ASSESSMENT REPORT

1 Lawson Square, Redfern SSD 5249 MOD 3

Figure 9: Eastern and western elevation of Tower 1 approved under MOD 2 (Source: MOD 2)

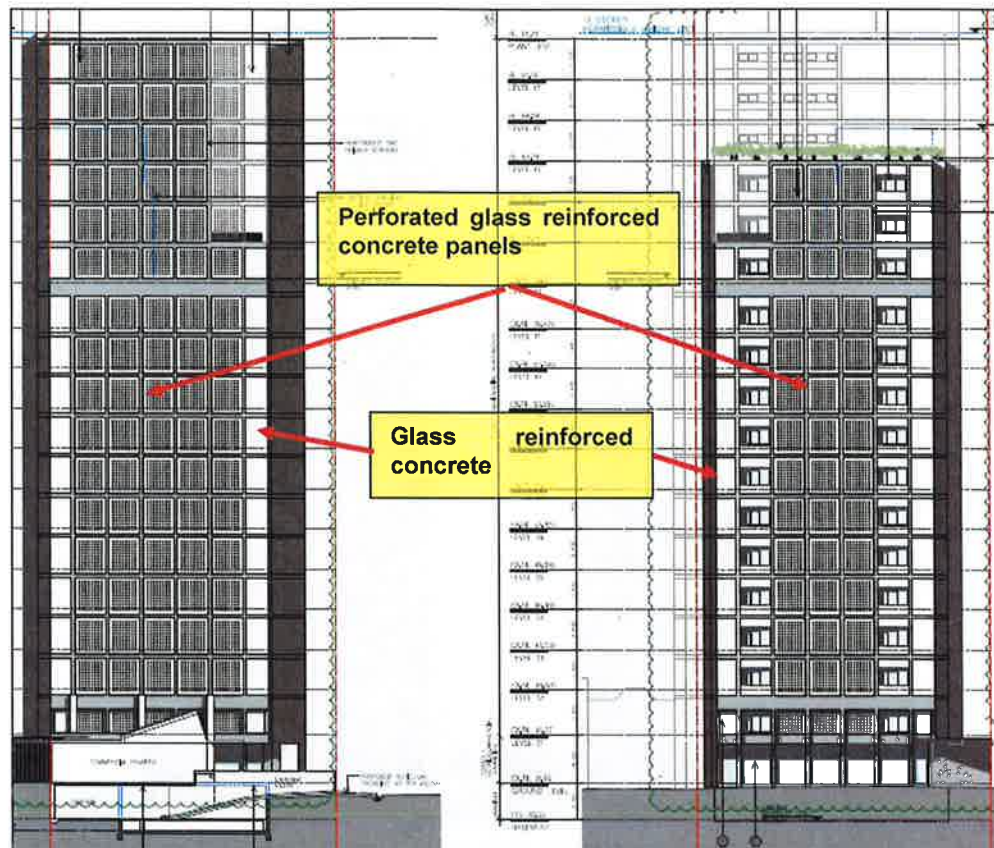
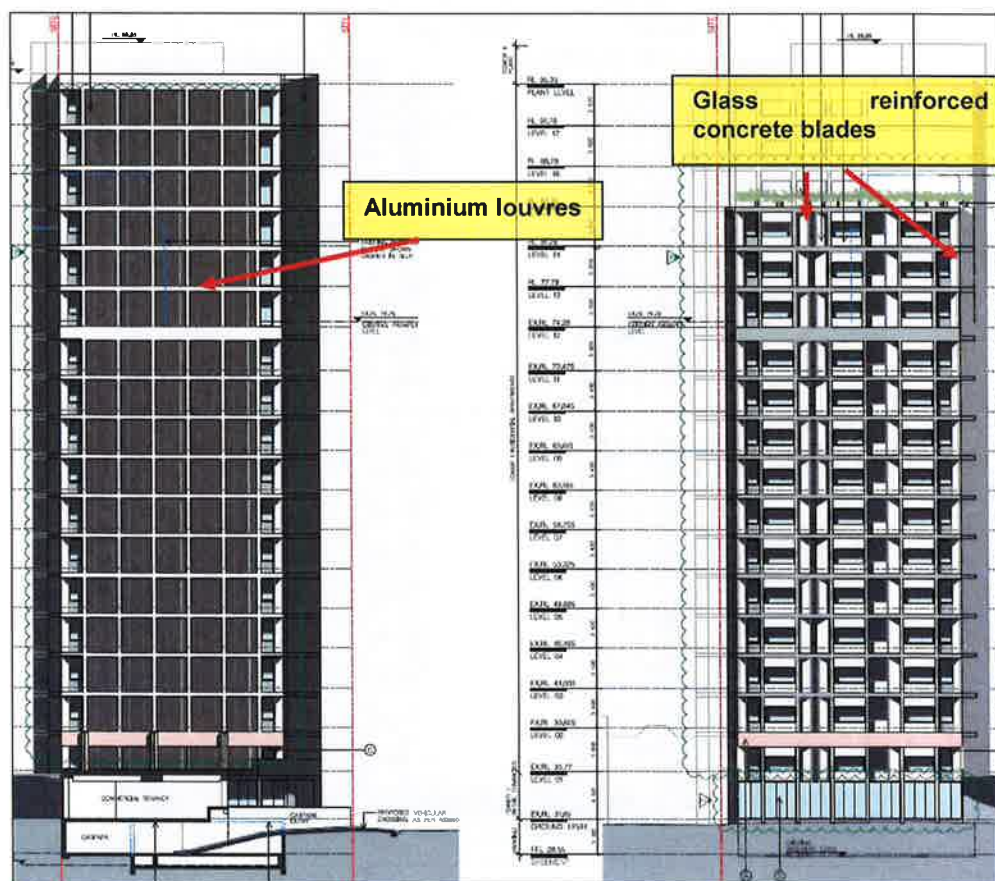
The approved perforated glass reinforced concrete screens are proposed to be replaced with glass reinforced concrete blades and aluminium louvres on the eastern and western facades of both of the towers (**Figures 9 and 10**). The changes would open up the facades of the towers and improve the internal amenity of the apartments by providing additional sunlight and views. The Department considers the changes to the towers would provide greater articulation and improved architectural expression and are therefore supported.

Figure 11: Southern elevation of Towers 1 and 2 approved under MOD 2
(Source: MOD 2)

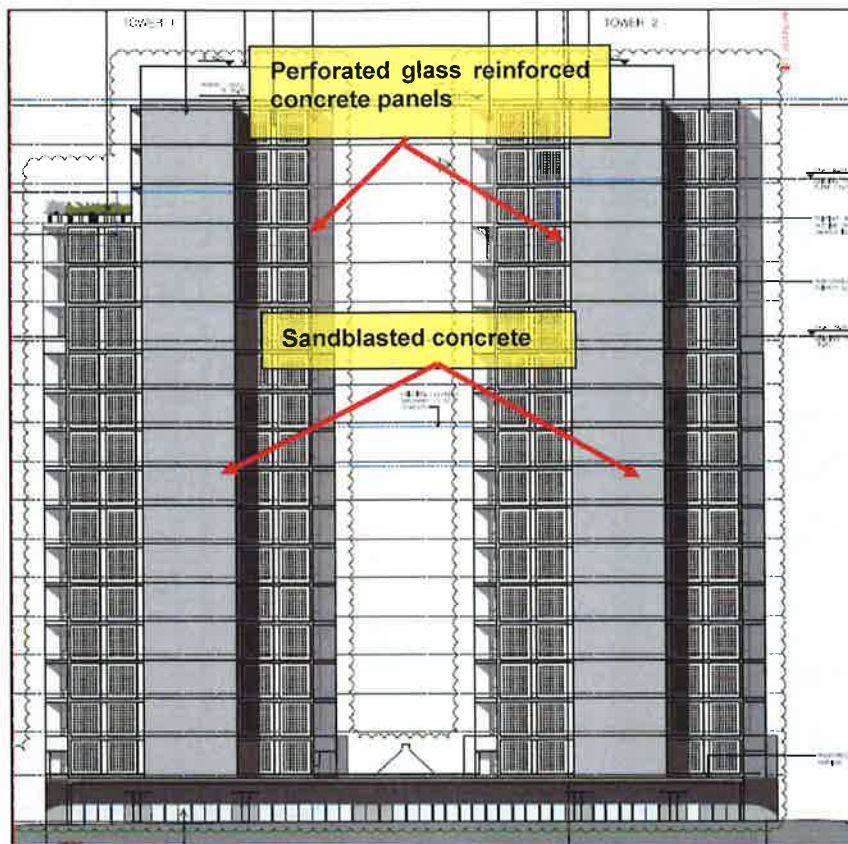
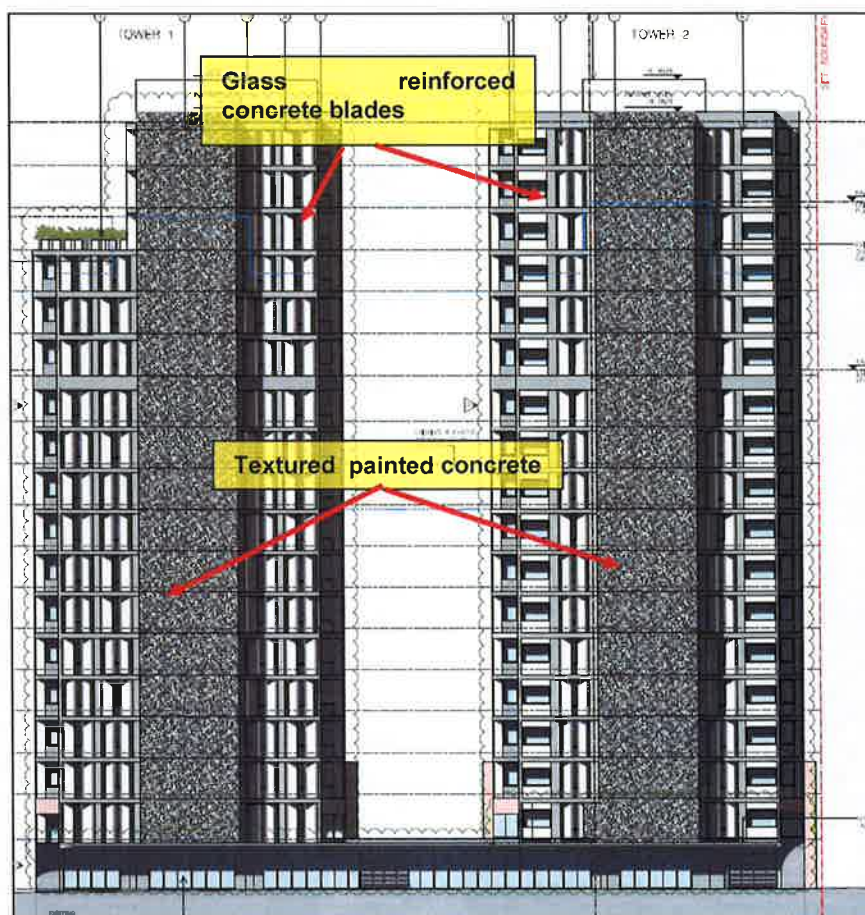
On the southern façade of the towers, the perforated glass reinforced concrete panels and sandblasted concrete would be replaced by glass reinforced concrete blades, glazing and textured painted concrete respectively (**Figures 11 and 12**). The Department considers the removal of the glass reinforced concrete panels would improve the articulation of the southern facades of the towers and provide greater vertical expression. This would act to reduce the façade's massing and improve the towers' proportions and visual appearance. The replacement of the sandblasted concrete with a textured maintained concrete would complement the overall palette of materials and maintain the overall aesthetic quality of the towers.

Figure 13: View lines between Tower 1 and 157 Redfern Street (Source: EIS for MOD 3)

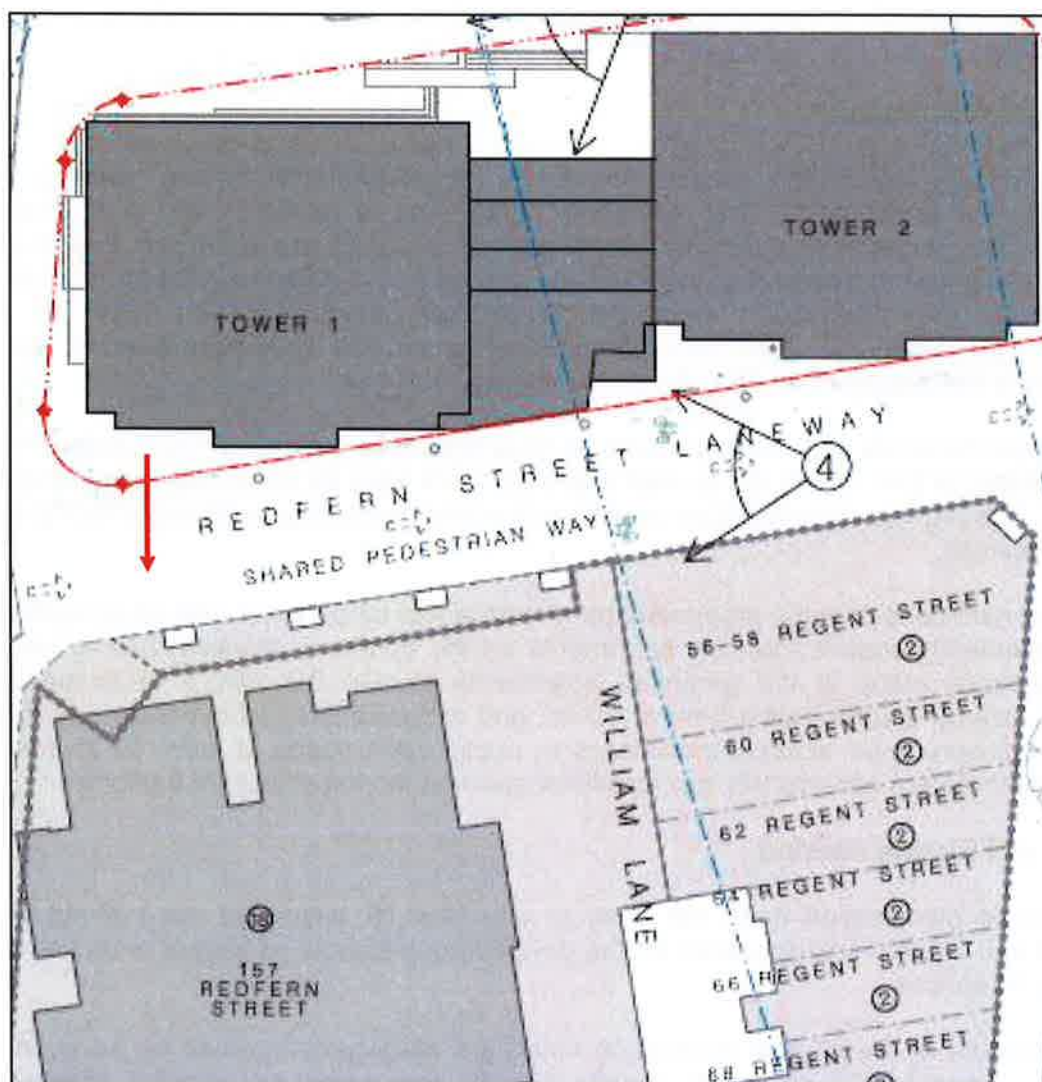
The modification seeks to remove the perforated glass reinforced concrete panels which face the southern residential apartment building at 157 Redfern Street. A public submission was received regarding privacy impacts from the south-facing windows of the western tower (Tower 1) to the north-facing apartments of 157 Redfern Street. The public submission raised concerns about the apartments in Tower 1 having bedrooms, living rooms and kitchen windows located to the south which would increase the potential for overlooking between the southern façades of Tower 1 and 157 Redfern Street.

The view lines between Tower 1 and 157 Redfern Street are identified at **Figure 13** below.

The Department considers the use of glass reinforced concrete blades and aluminium louvres which are appropriately glazed and angled, ensure that a reasonable level of privacy would be maintained to the adjacent residents at 157 Redfern Street. Additionally, the changes proposed to the layout of apartments on the southern elevation would ensure that living areas are orientated away from the south to mitigate overlooking potential. The Department further notes the residents at Tower 1 and 157 Redfern Street are separated by approximately 17.1 m which also mitigates overlooking potential.

The Department concludes the proposed development would maintain acceptable levels of privacy to the residents of 157 Redfern Street.
